About the application

Application number: 2020/93467	
What is the application for?:	Erection of gates and gate posts
Address of the site or building:	Brigsteer, 402, Birkby Road, Birkby, Huddersfield, HD2 2DN
Postcode:

CLIENT:	
ACUMEN	
JOB TITLE:	
GATEPOSTS AT 402 BIRKBY ROAD, HUDDERSFIELD	
DRAWING TITLE:	
PROPOSED SITE PLAN & ELEVATION	
DRAWN: JF	DATE: Sep
CHECKED: JC	SCALE: 1:200 @ A1
DRAWING NUMBER:	2532 - 12

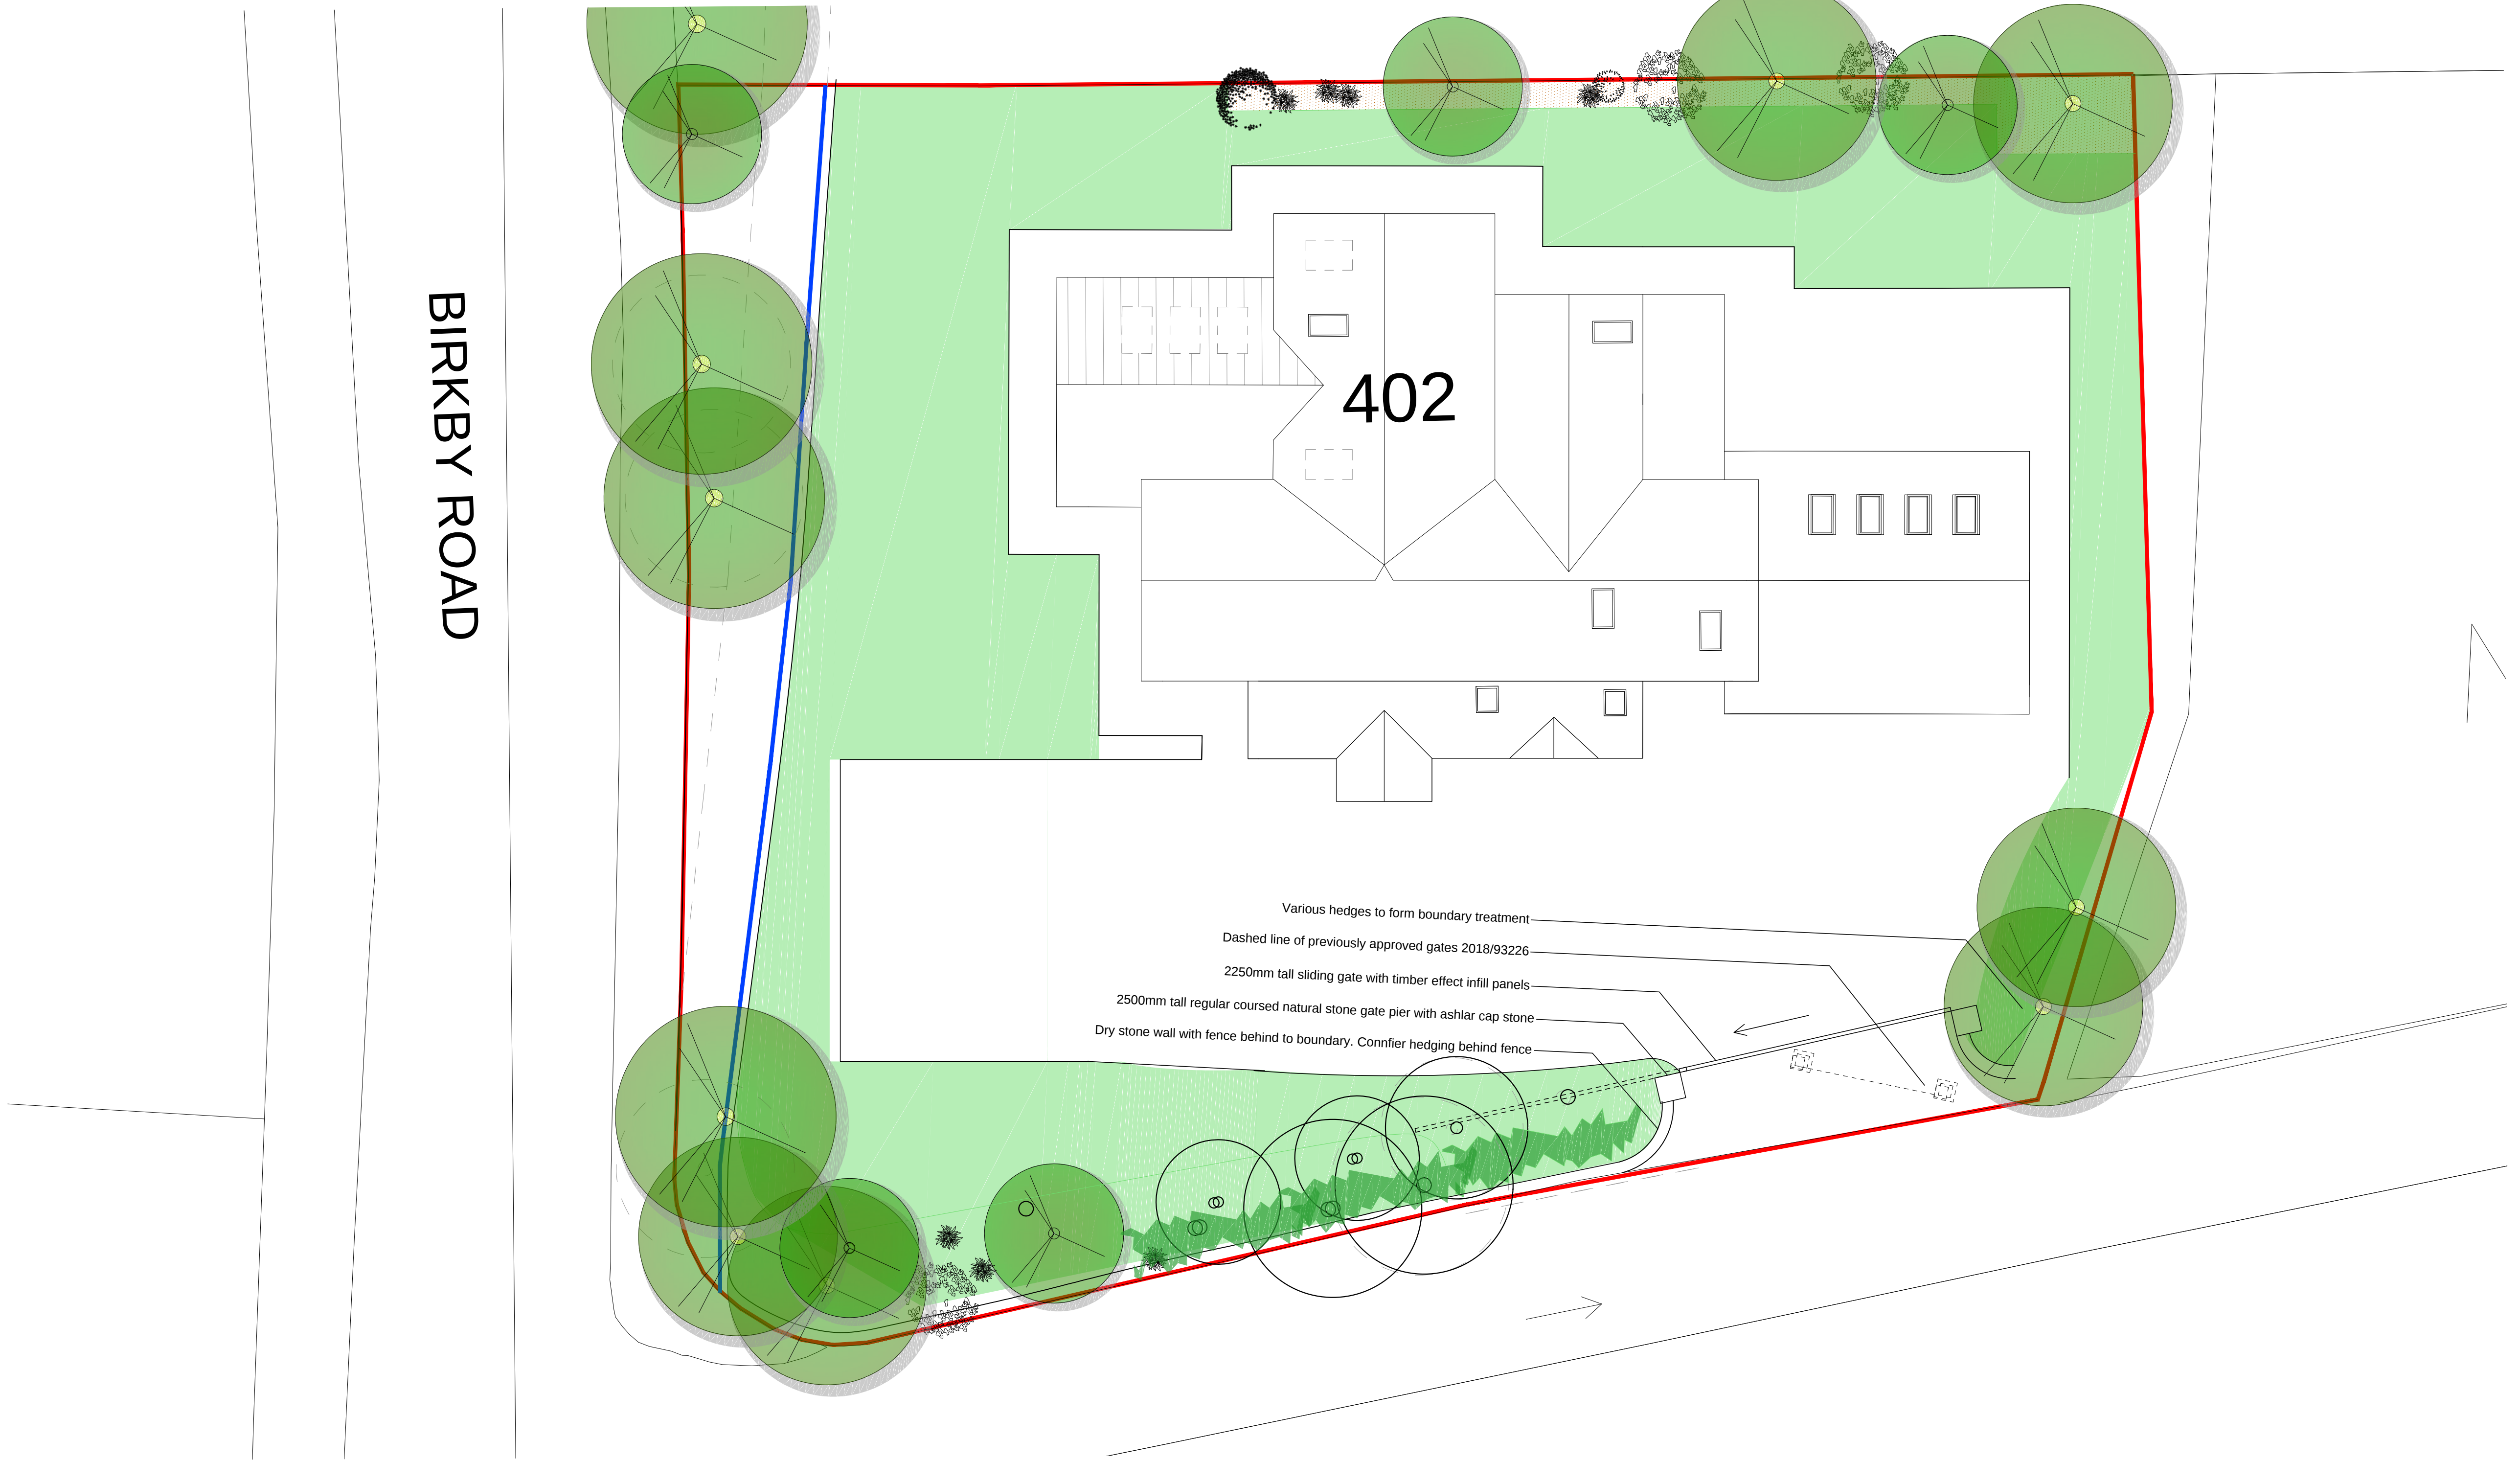
Type of comment: A general comment
I regularly pass this house whilst walking along birkby road and do find the gates to this property rather imposing. I certainly dont feel they fit with the style of the nearby houses.
